**Re: Kendall Subaru – PA22-035 – Technical Review 1
16xxx Smokey Point Blvd – APN(s): 31052800300600 / 31052800300300 /
31052800301200**

Re: **Kendall Subaru – PA22-035**
IECO No. 20-1092

The project referenced above is revised in response to the review comments dated September 15, 2022. The review comments are numbered on the letter and have been addressed in *italics* as follows:

ROAD AND DRAINAGE PLAN **C3.0**

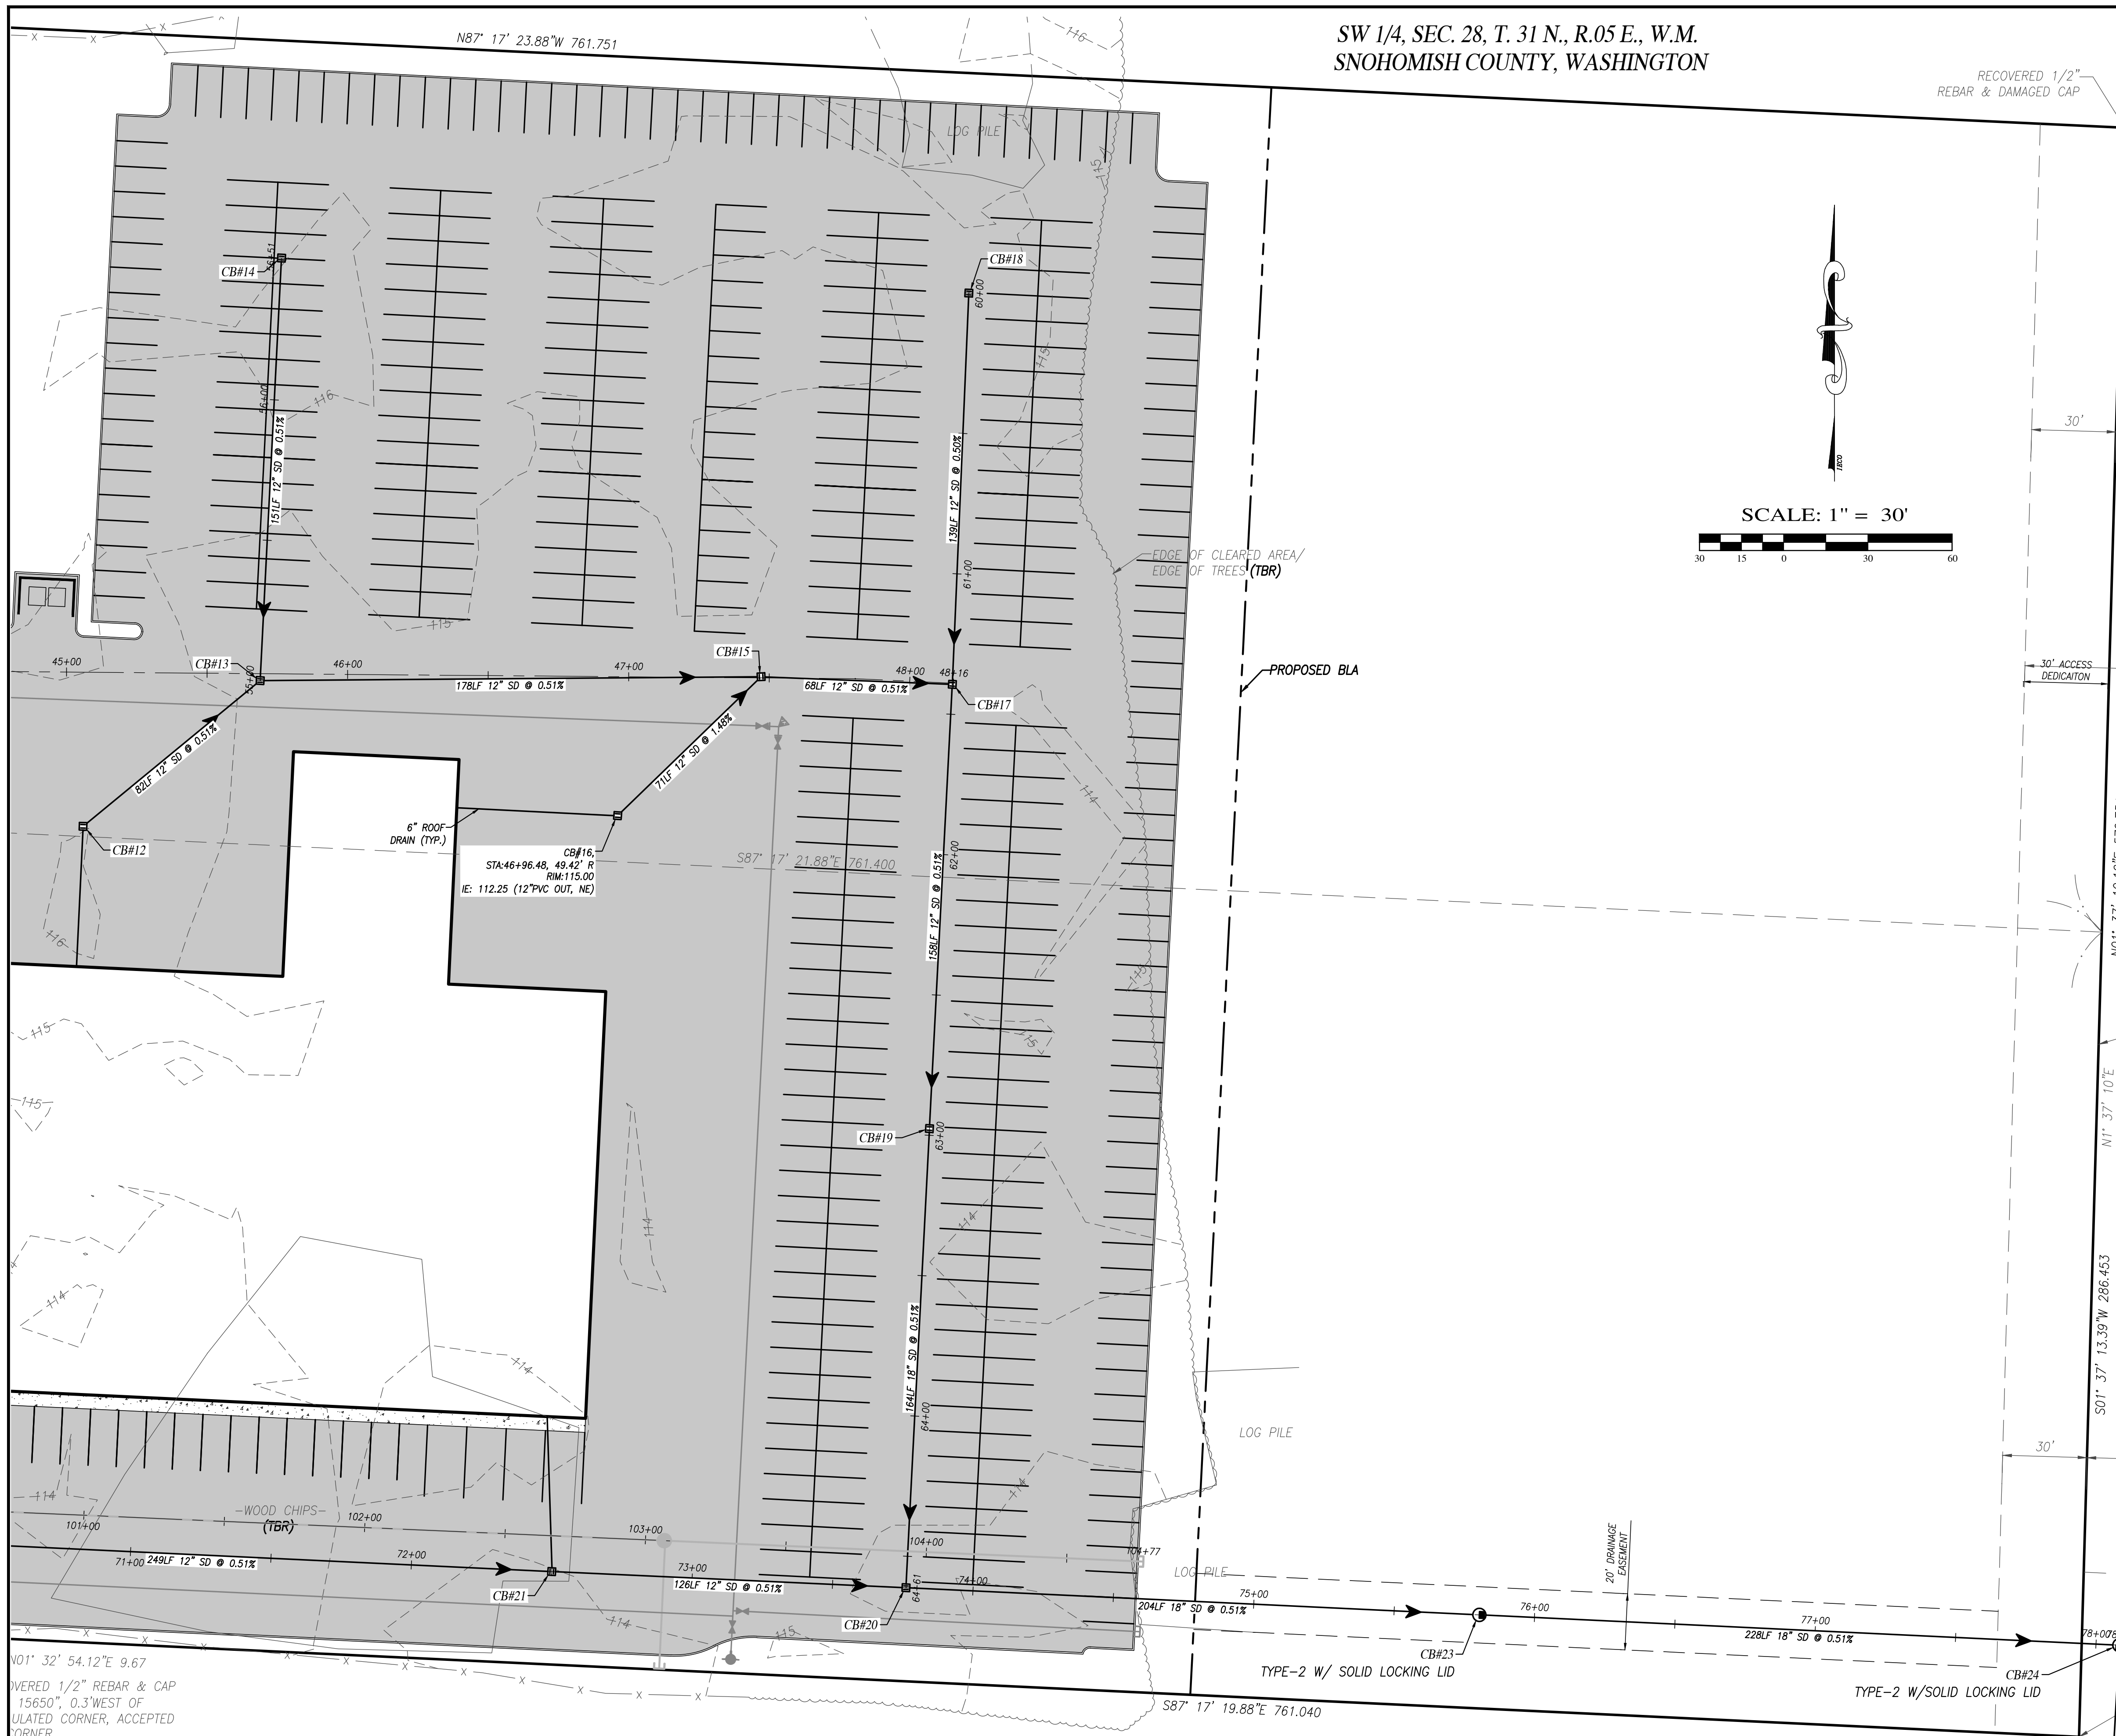
6. Drainage: All projects in the city of Marysville must comply with requirements stipulated under the MMC 14.15.040 and 14.15.050.
 - a. Stormwater drainage: The city has adopted the 2019 Ecology Manual. Projects above the 2,000 square feet threshold must comply with requirements stipulated in Volume I, Chapter 2 of the Stormwater Management Manual for Western Washington.
 - b. A geotechnical report has been provided.
 - c. The maximum allowed impervious surface coverage for the Zoning designation is 85%.
 - d. Projects that are not submitted prior to 7/1/22 will be required to be compliant with the 2019 Ecology manual.

Please refer to the drainage report and geotechnical report along with this submittal.

**1** 80' RIGHT-OF-WAY ROAD SECTION  
**C5.0** SMOKEY POINT BLVD.  
NO SCALE ROAD CLASSIFICATION: ARTERIAL  
DESIGN SPEED: 30 M.P.H.

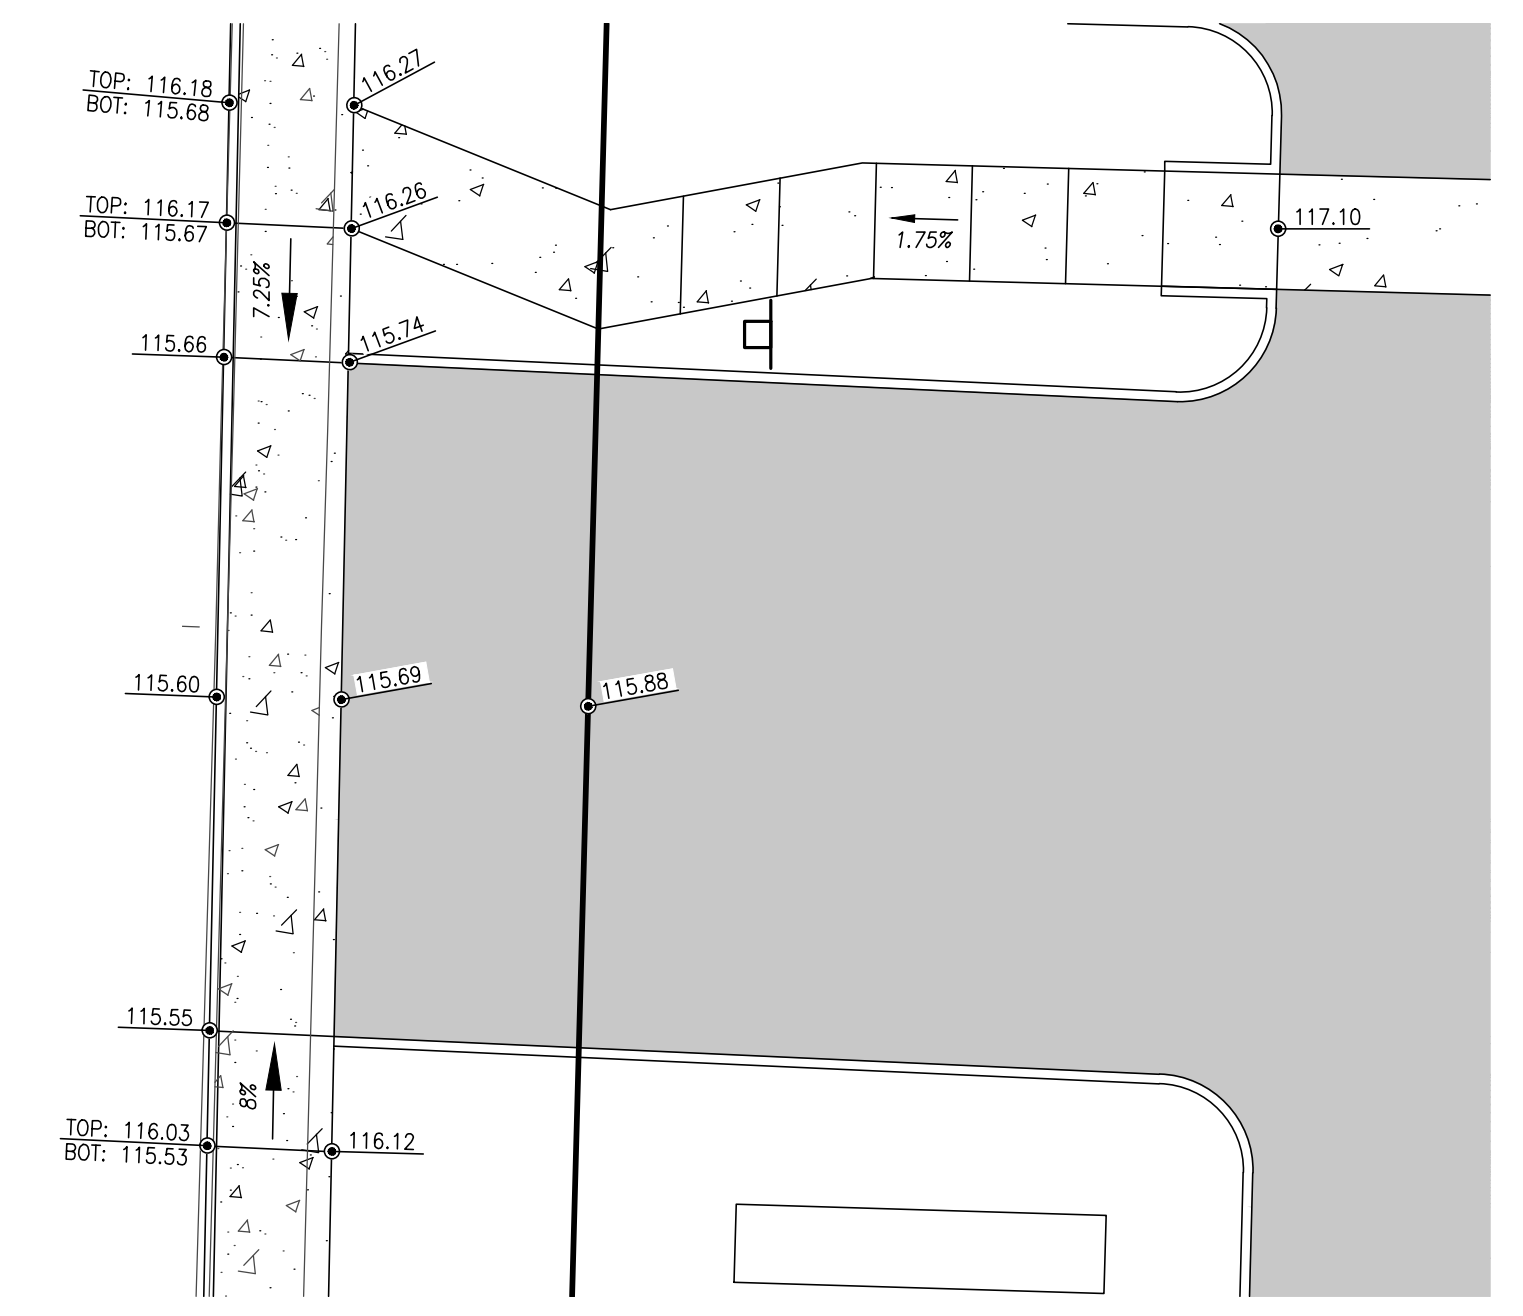
3. Frontage Improvements: Frontage improvements are required per MMC 12.02A.090 on all projects. Frontage improvements are described as curbs, gutters, and sidewalks; underground storm drainage facilities; patching the street from its preexisting edge to the new curb line; and overlayment of the existing public street to its centerline.
 - a. The sidewalk along Smokey Point Blvd. is adjacent to the curb, as such it is to be a 6 foot wide sidewalk. The sidewalk shall be removed and replaced with a 6 foot sidewalk.

Please refer to the revised cover sheet.

**160TH ST EXTENSION**  
NOT TO SCALE DESIGN SPEED = 25 MPH  
NEIGHBORHOOD COLLECTOR 60'  
RIGHT-OF-WAY PER STD. PLAN 3-202-001

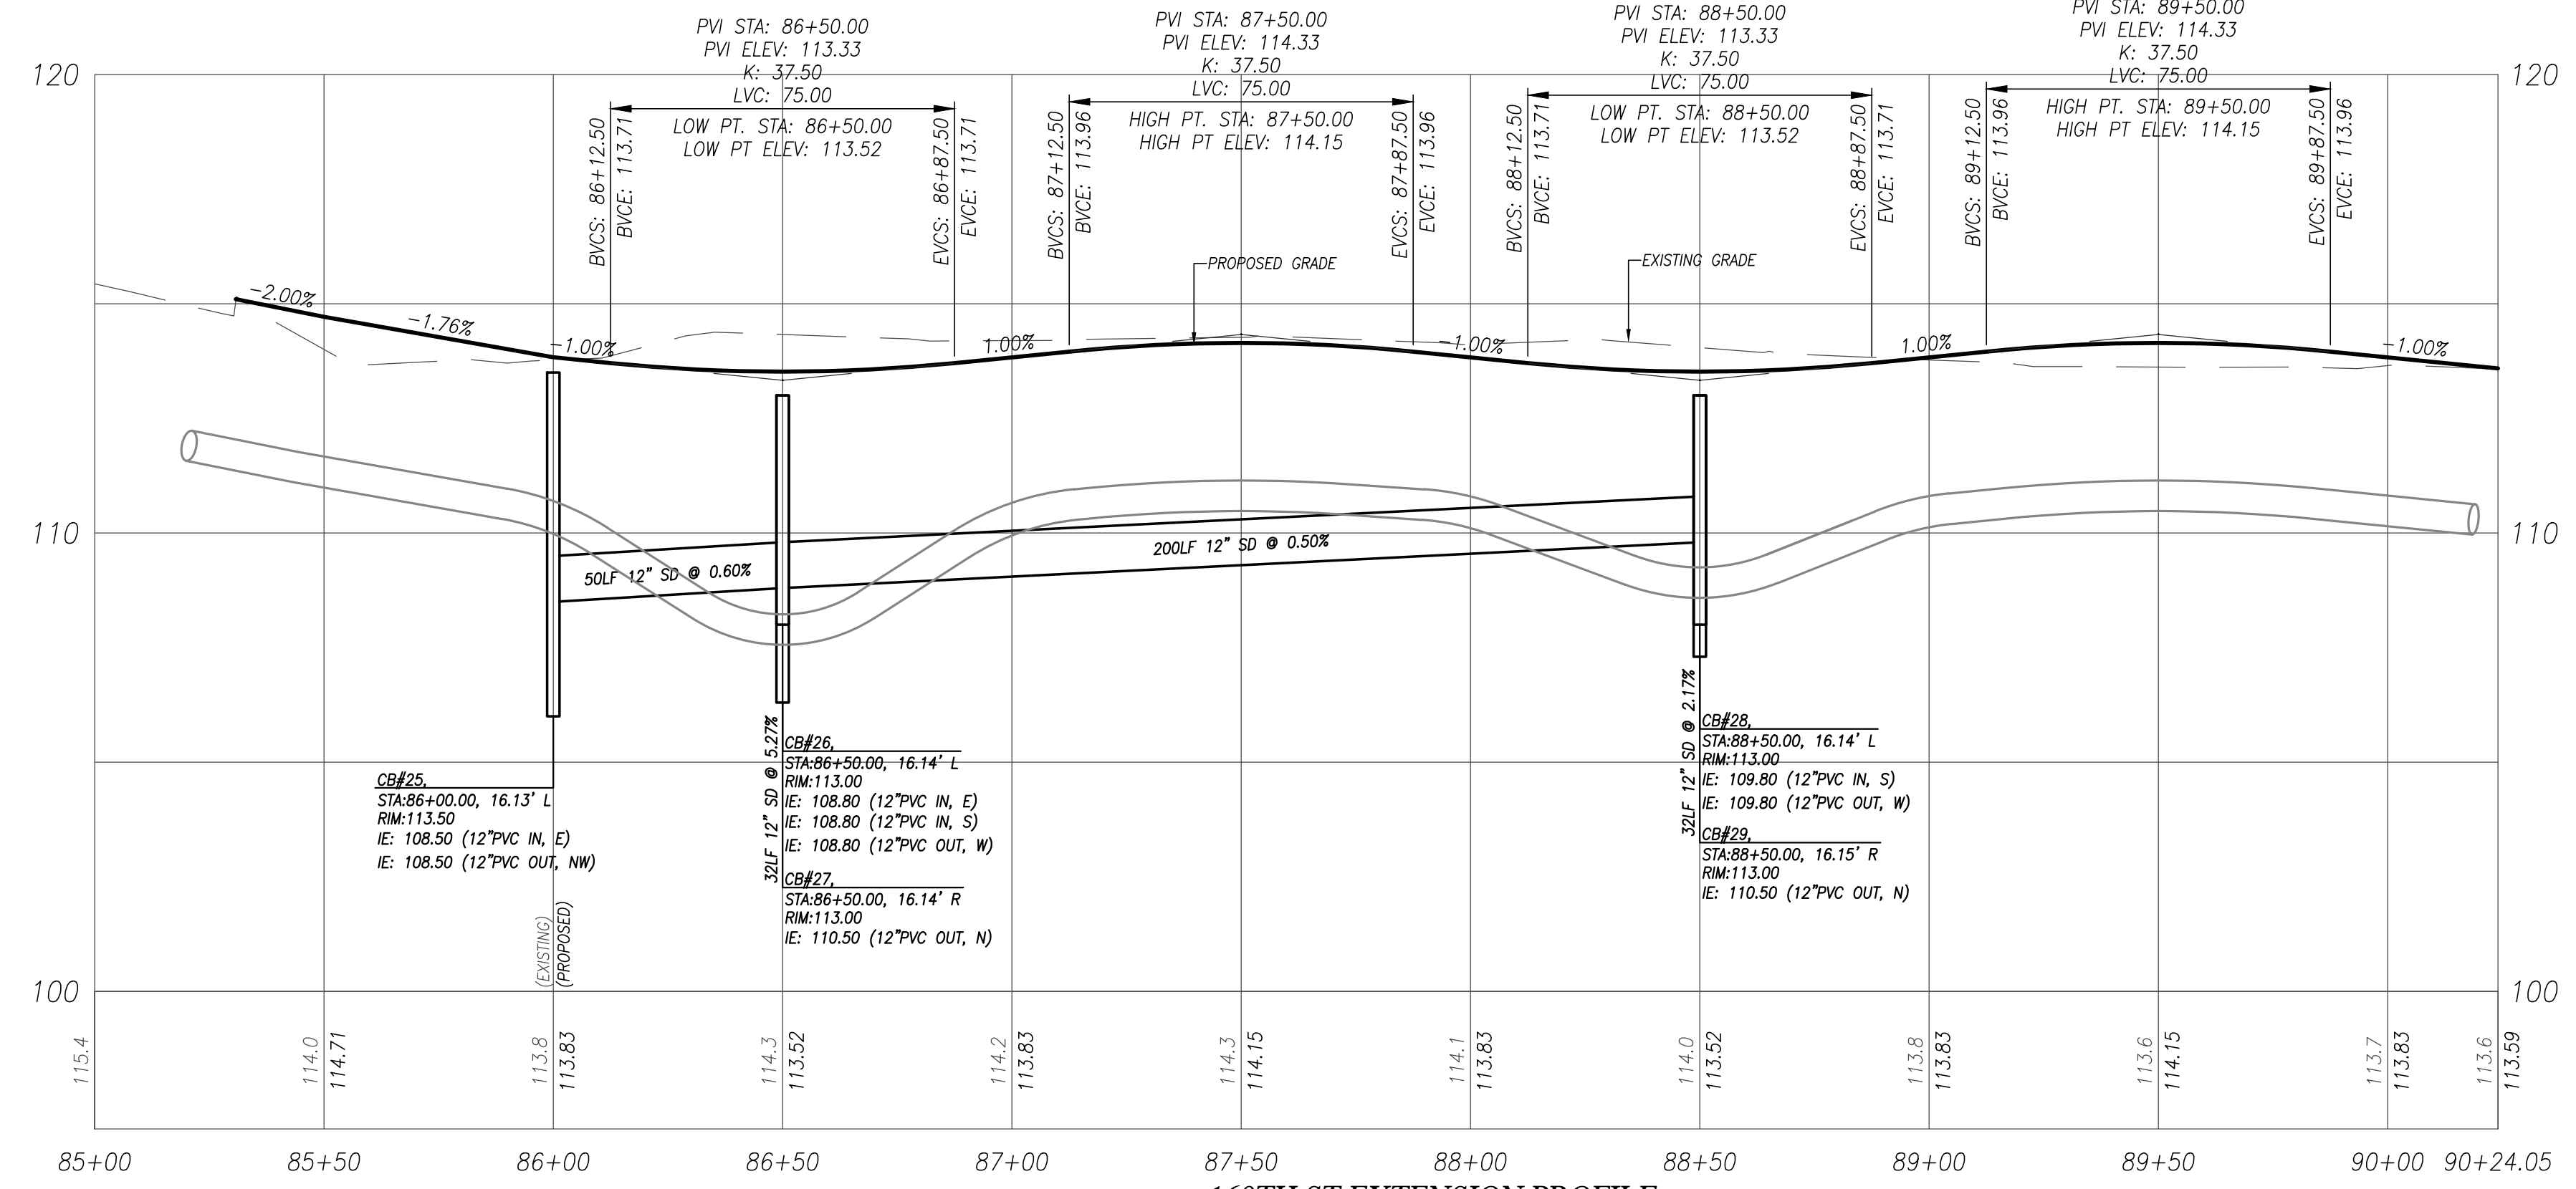
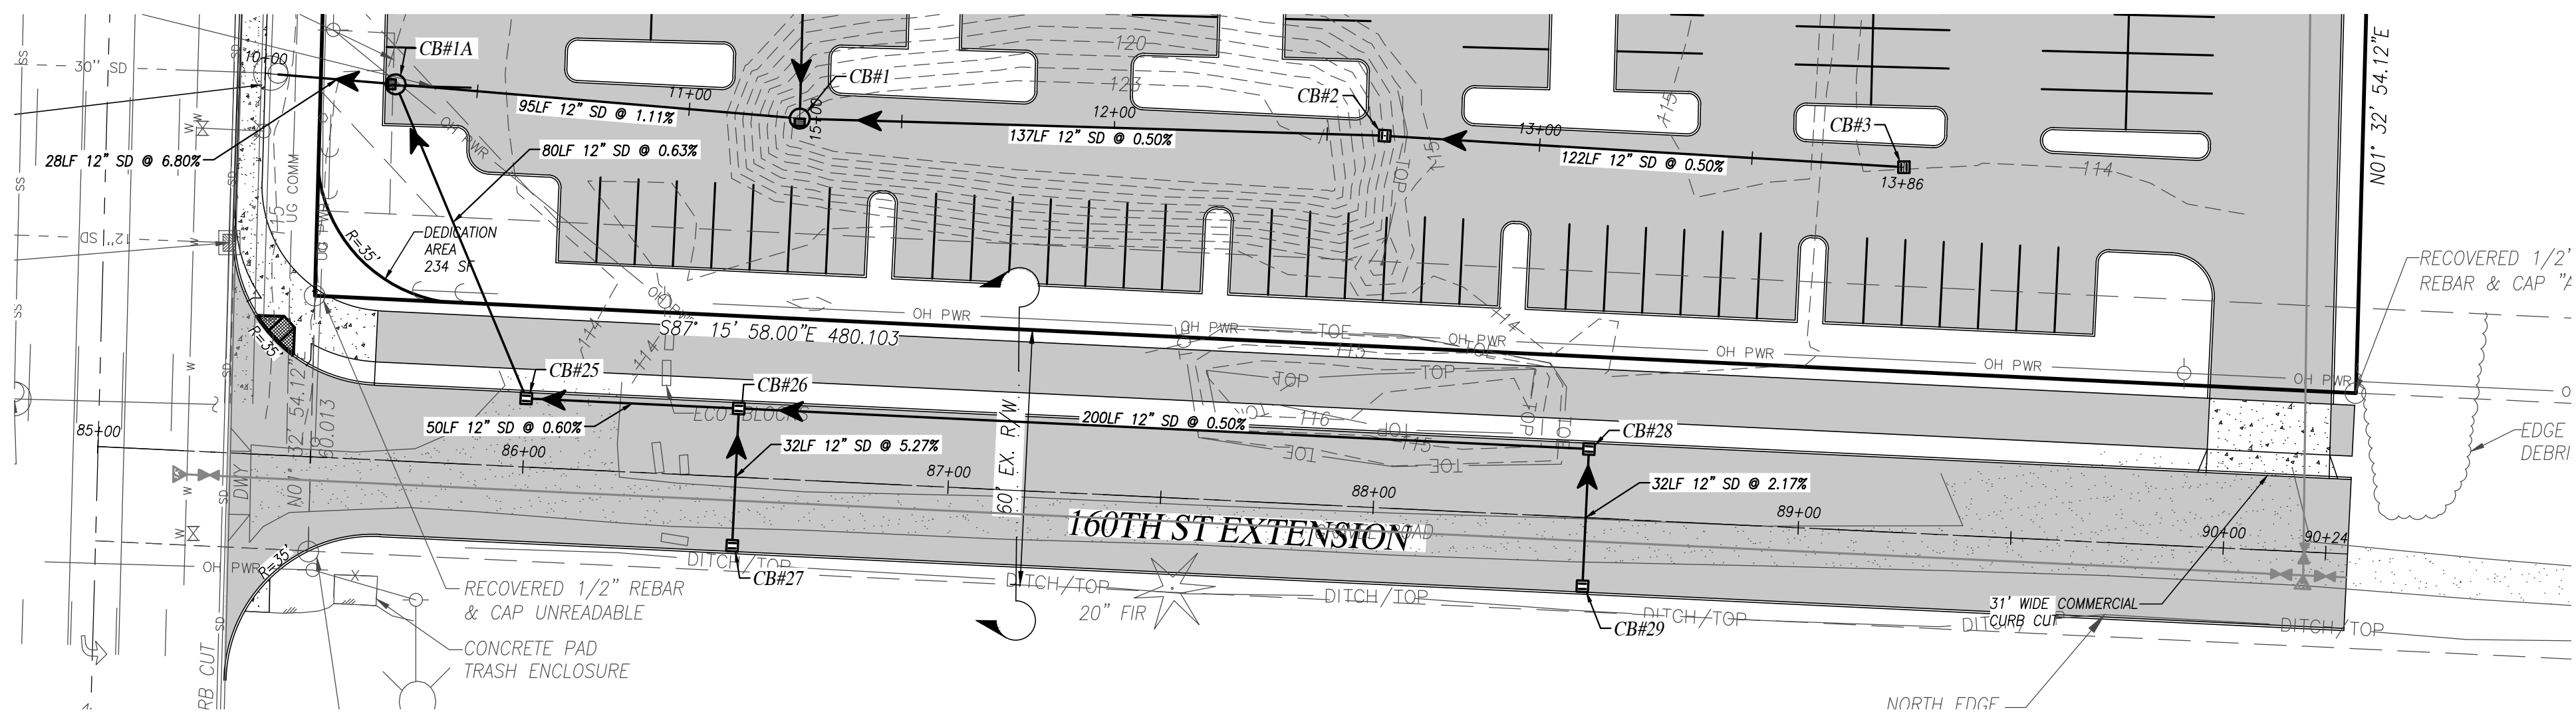
- b. 160th Street is to be a 3 lane arterial with planter strips and a 12 foot multiuse path. The project is required to construct a half street for asphalt, which is 20 feet in width and the curb and gutter, a 5 foot planter strip and the multiuse path.

Please refer to C5.1 for 160th St for profile and cross section.
